COMMUNITY DEVELOPMENT DEPARTMENT
501 Delta Avenue ♦ Marysville, WA 98270 ♦ (360) 363-8000

Re: Stack Short Plat (SP22006) 2nd Submittal Technical Review Comments

RE: Stack Short Plat, File# SP22-006
5 Lot Short Plat
3807 122nd Street NE & Parcel # 30050900202200

**SP-01**  
 SHEET 3 OF 6

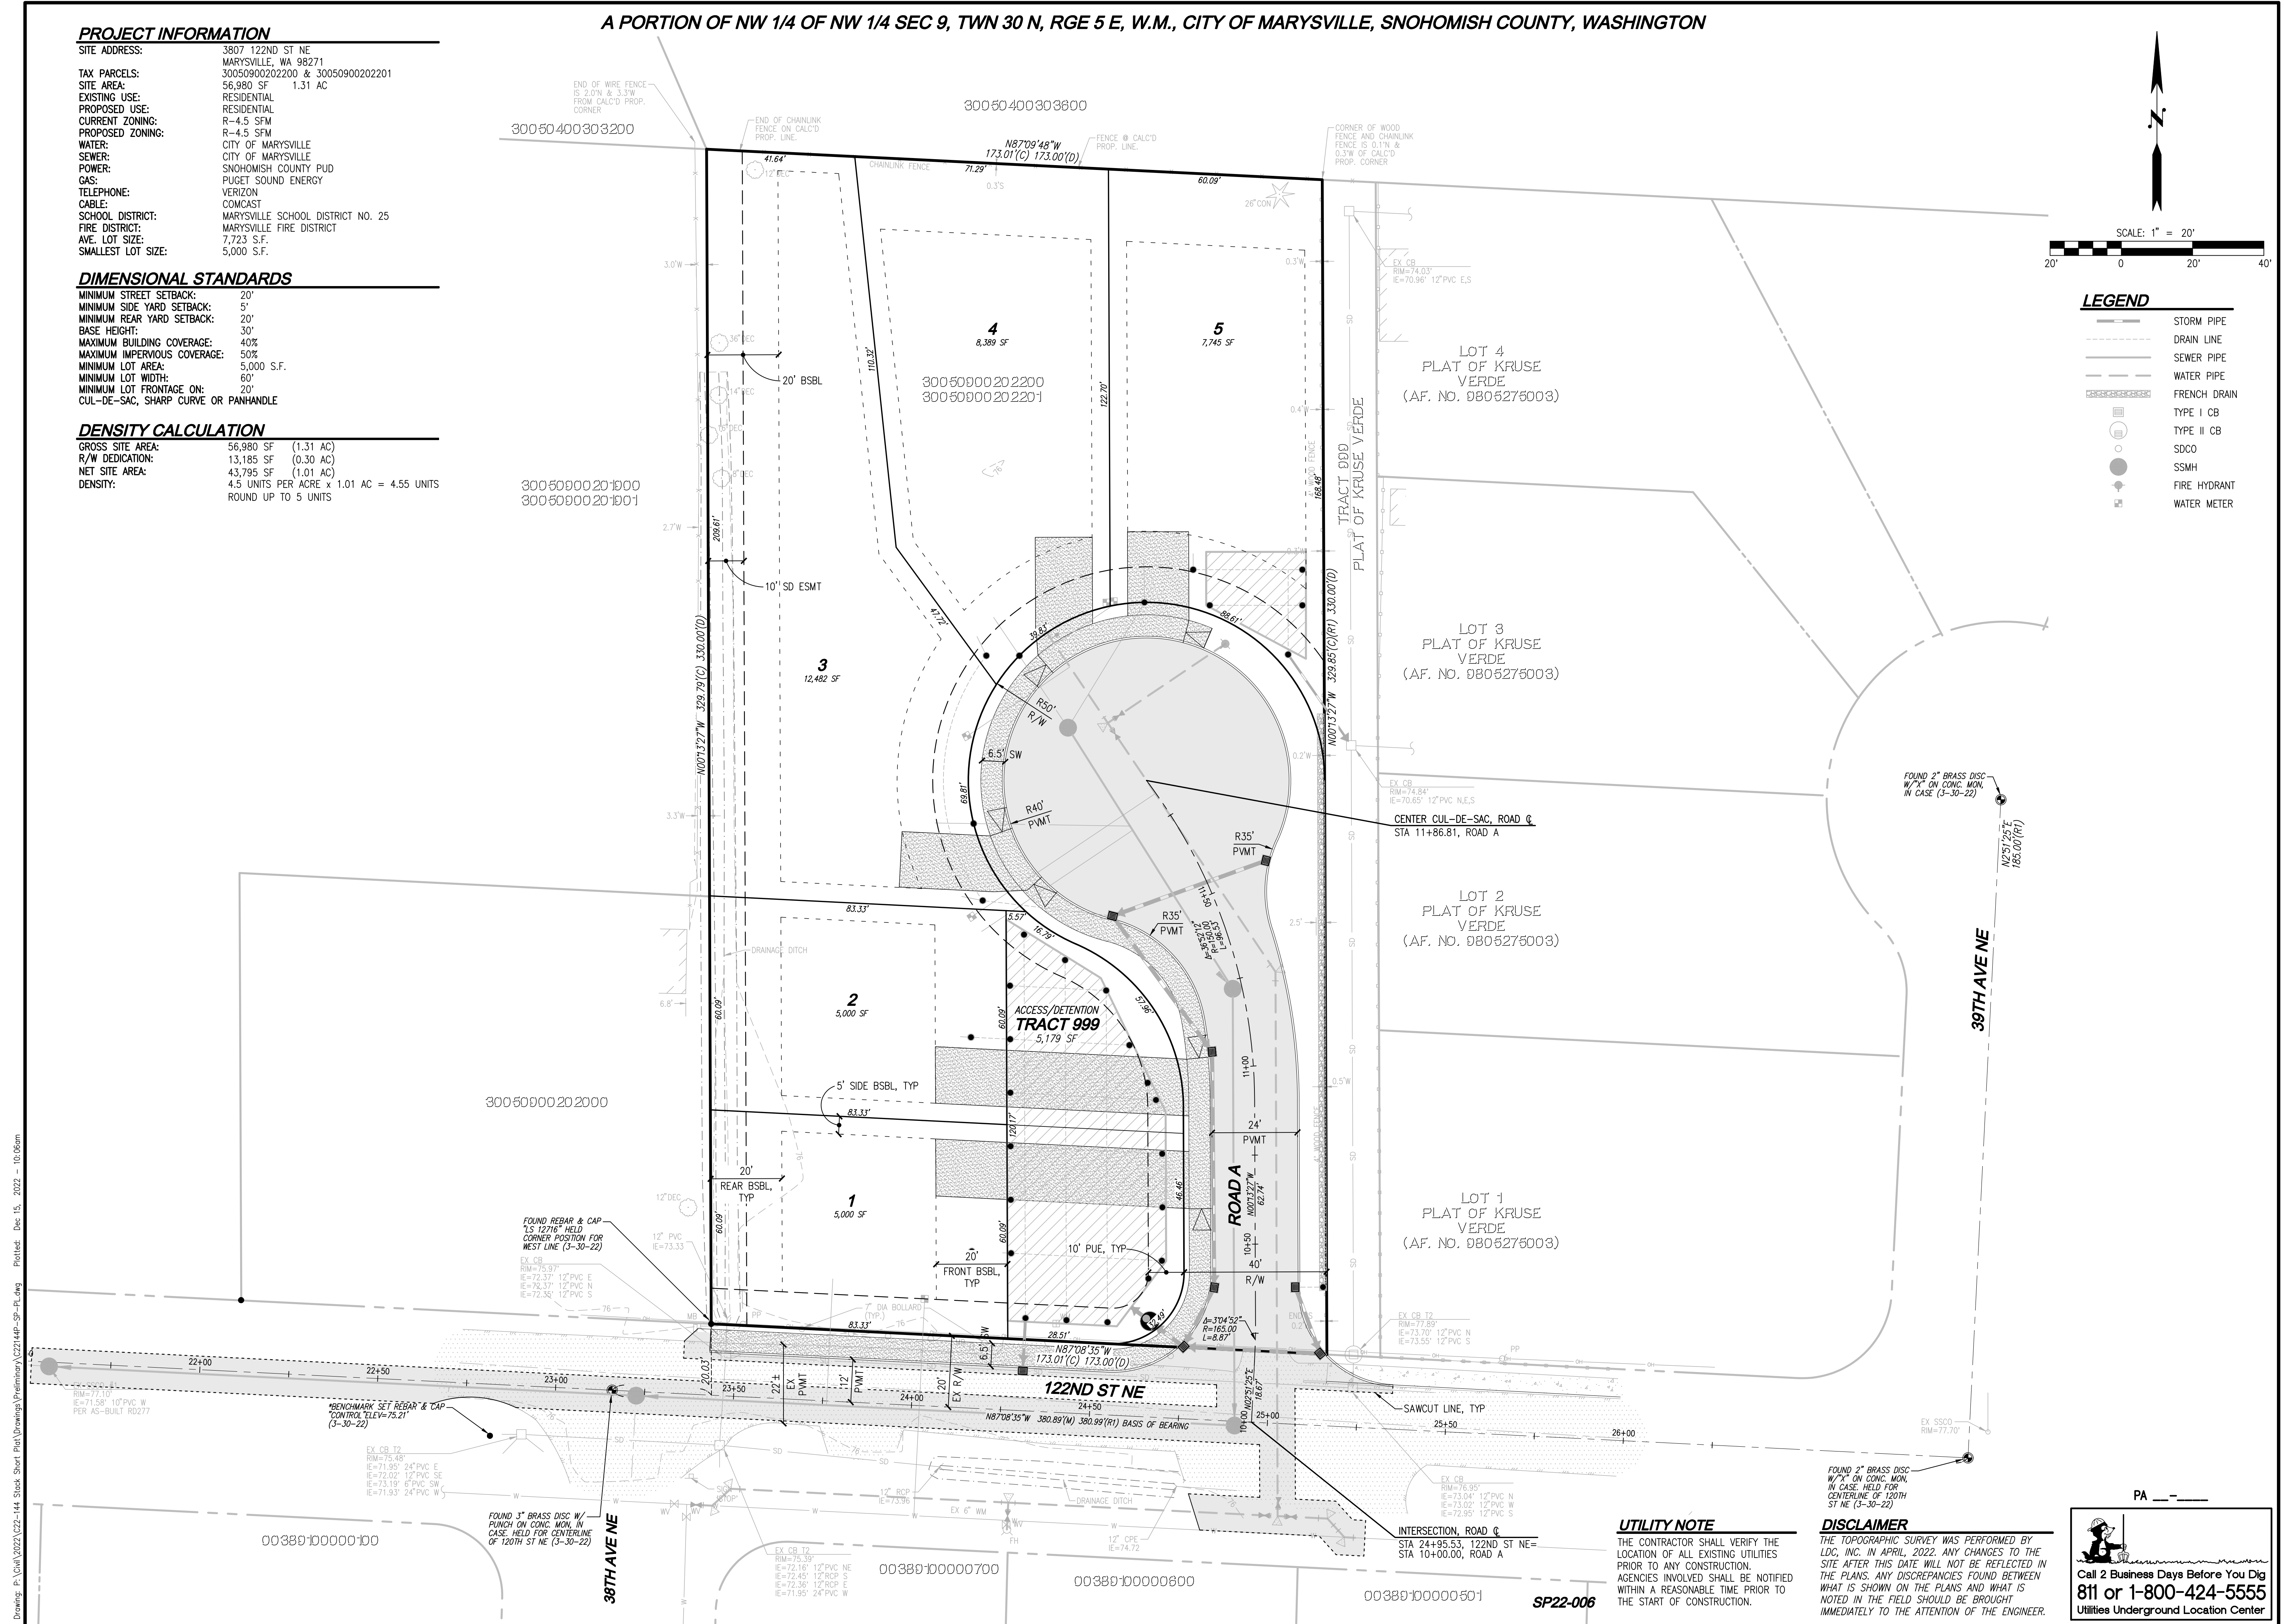
1. **TRC1 Comment:** Tract 999 labeled as “Access/Detention” on the provided preliminary plan needs to be relocated behind Lots 1 & 2. Access for maintenance of the Tract shall come from 122nd Street NE. Revise the plans showing the tract relocation and access coming from 122nd Street.

TRC2 Comment: The entirety of Tract 999 will be required to be relocated west behind Lots 1 & 2 adjacent to APN 30050900202000, not the overflow path exclusively. Tract 999 shall not include private driveway access. Maintenance access to Tract 999 will be allowed to be accessed off of 122nd Street NE.

2. **TRC1 Comment:** Public works is currently reviewing the proposed EDDS Deviation request to eliminate the sidewalk on the east side of the cul-de-sac.

TRC2 Comment: The revised variance is under review by the Assistant City Engineer.

1. This design is not ideal. The private driveways will be utilized for parking. The cars and private use of the property will limit the City's ability to inspect and maintain the facility. I would rather see the facility in an area that is not encumbered by private property uses.

TR1C Response: The proposed overflow path has been revised. Infiltration Gallery #1 will overflow to the south by connecting to the existing City of Marysville stormwater system located within 122nd Street.

STACK DESIGN & CONSTRUCTION, LLC  
**STACK SHORT PLAT**  
 PRELIMINARY ROAD, GRADING AND STORM DRAINAGE PLAN

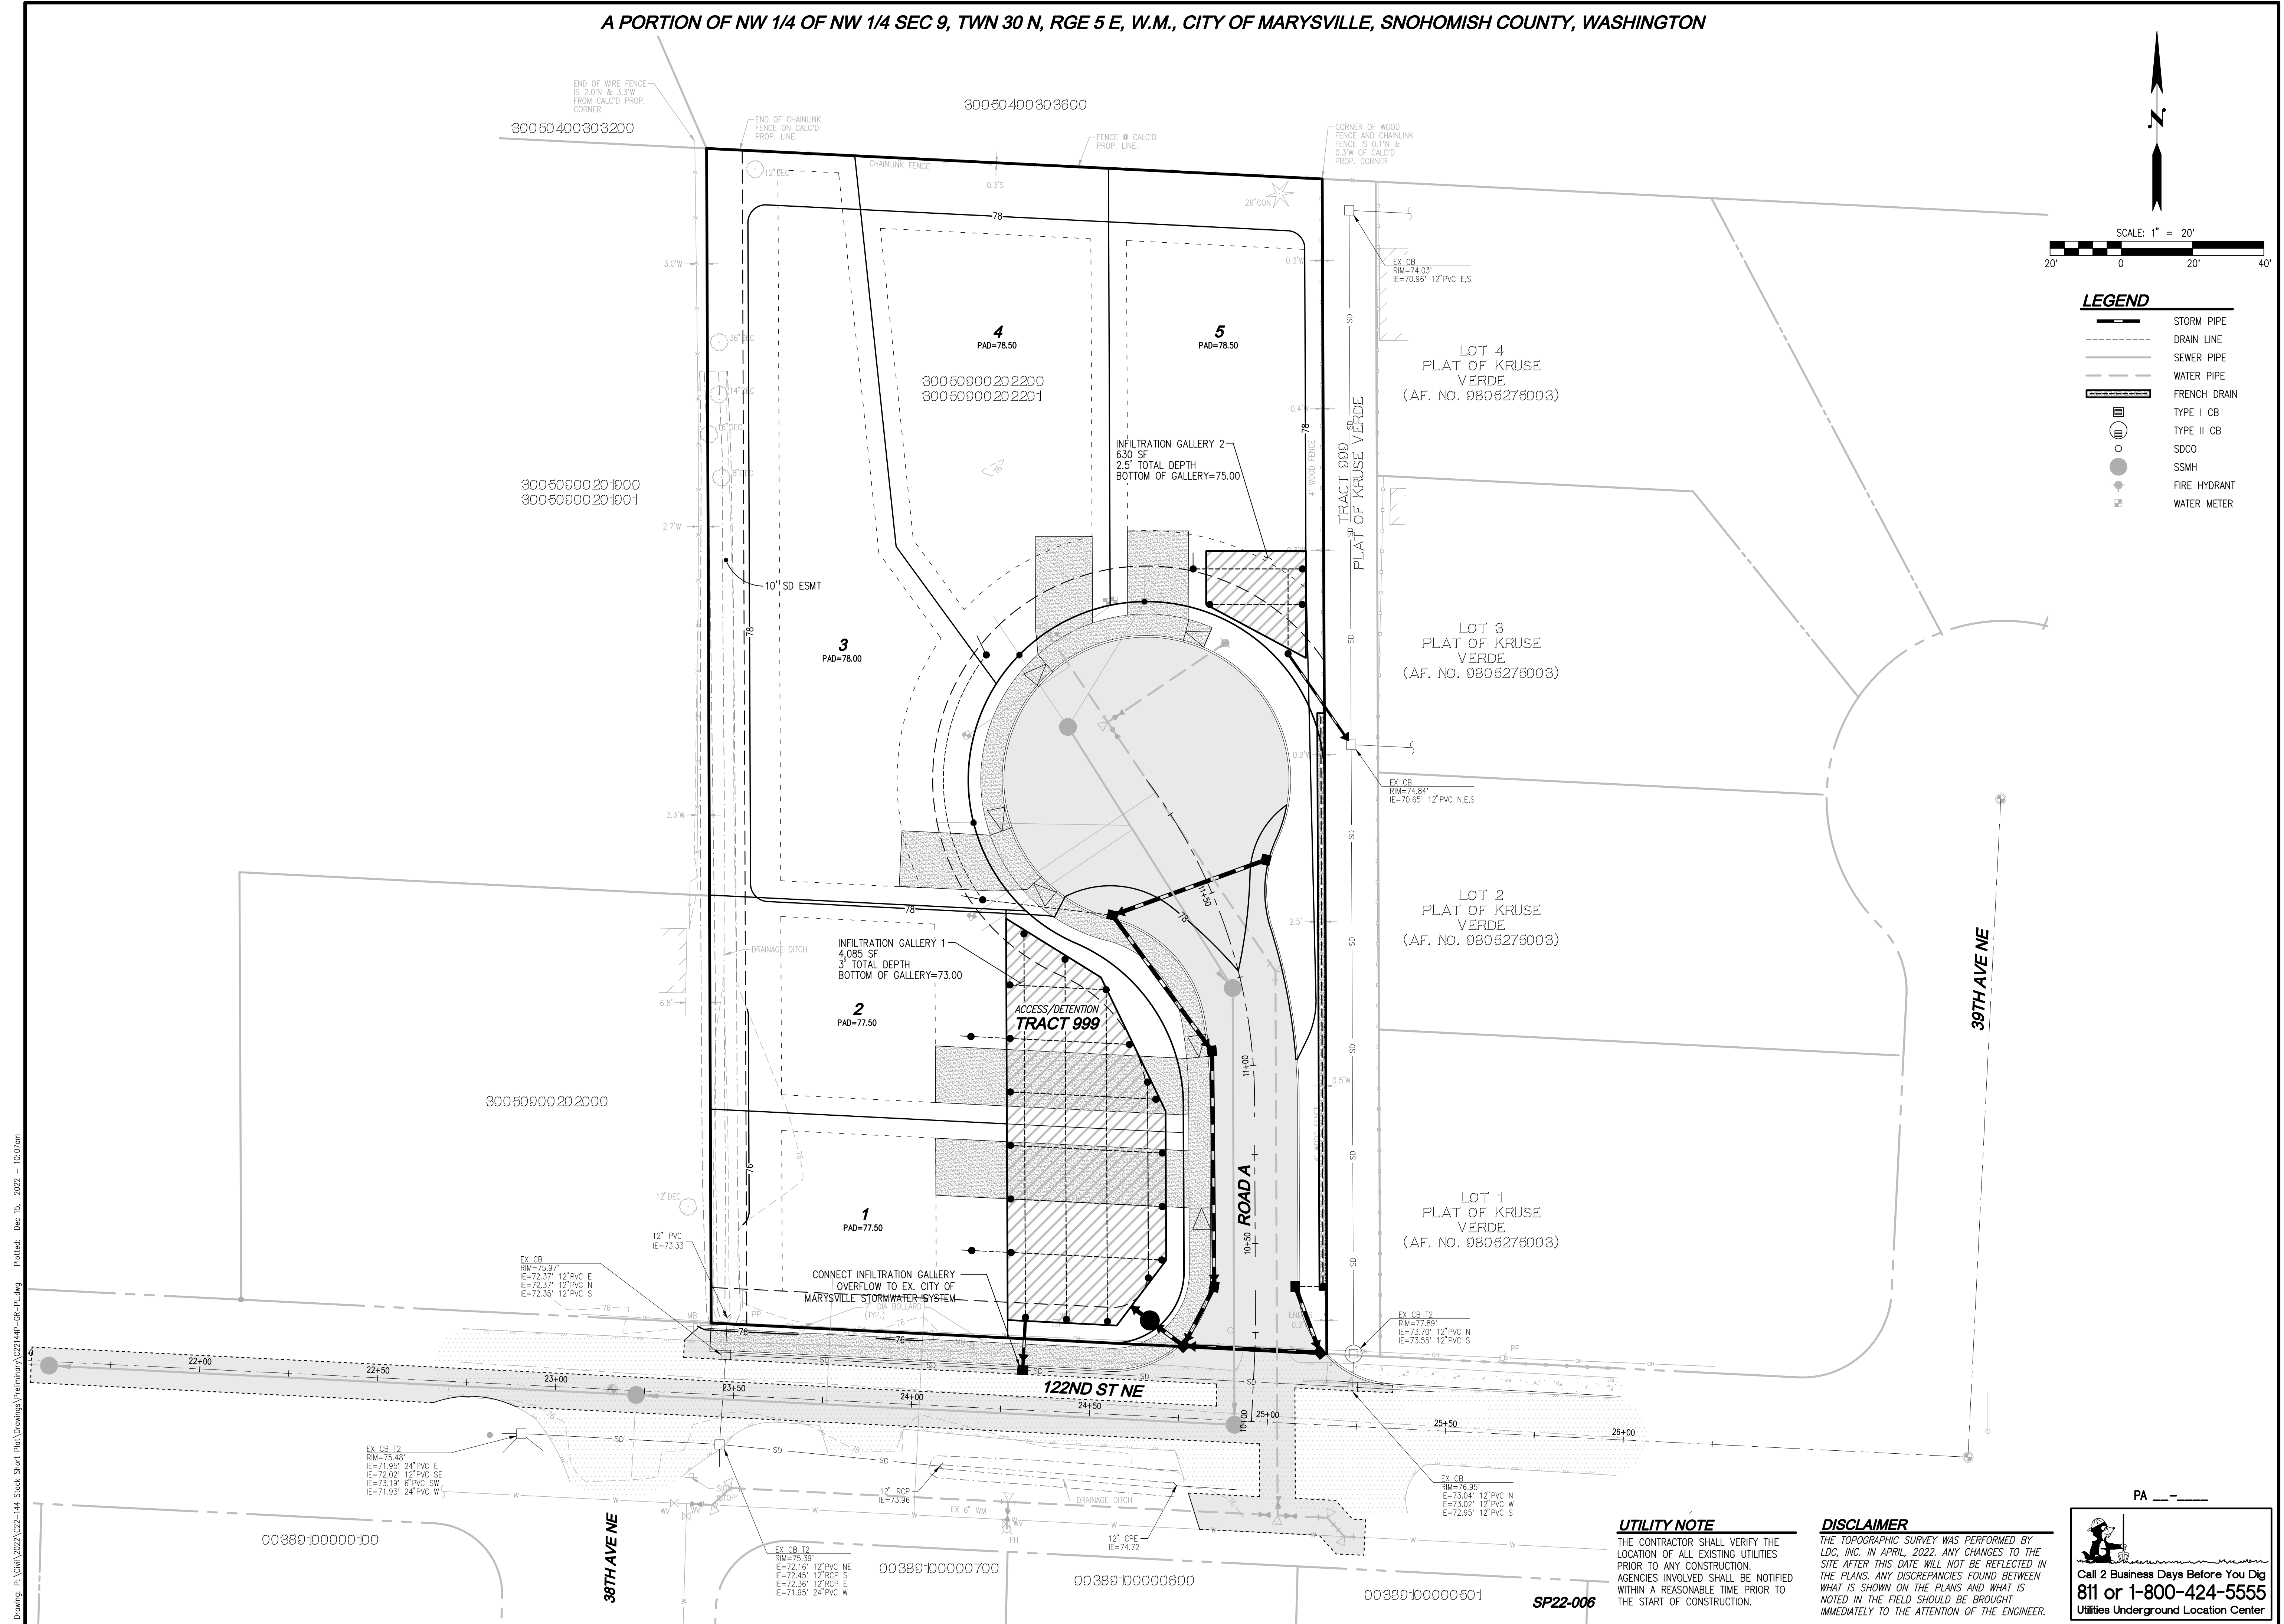
- a. Stormwater drainage: The city has adopted the 2019 Ecology Manual. Projects above the 5,000 square feet threshold must comply with requirements stipulated in Volume I, Chapter 2 of the Stormwater Management Manual for Western Washington. The following revisions will be required in future submittals:
 - *Please clarify about the separation of the infiltration facilities from the groundwater table. In what has been provided, it seems that there will not be the minimum 3 feet of separation from the bottom of the facilities. The mounding analysis states that the facilities will function with only 2 feet of separation, however the minimum standard is 3.*
 - At time of civil plan review, a conveyance analysis will be required.
- b. A geotechnical report and a mounding analysis have been submitted.
- c. The maximum allowed impervious surface coverage for the Zoning designation is 50%.

2. The City has adopted the 2019 Stormwater Management Manual for Western Washington.
 - The infiltration facility is required to implement the UIC design criteria found in Volume I Chapter 4 and the associated permitting through Ecology.

- Infiltration facilities that receive water from pollution generating surfaces are required to have pretreatment.
3. For residential projects triggering minimum requirements #6 Runoff Treatment and #7 Flow Control, the stormwater facility lot will be dedicated to the HOA or residents, when there are amenities for private use. The HOA/residents will be required to maintain any landscaping and the private driveways. The City will receive an easement to maintain the stormwater infrastructure.
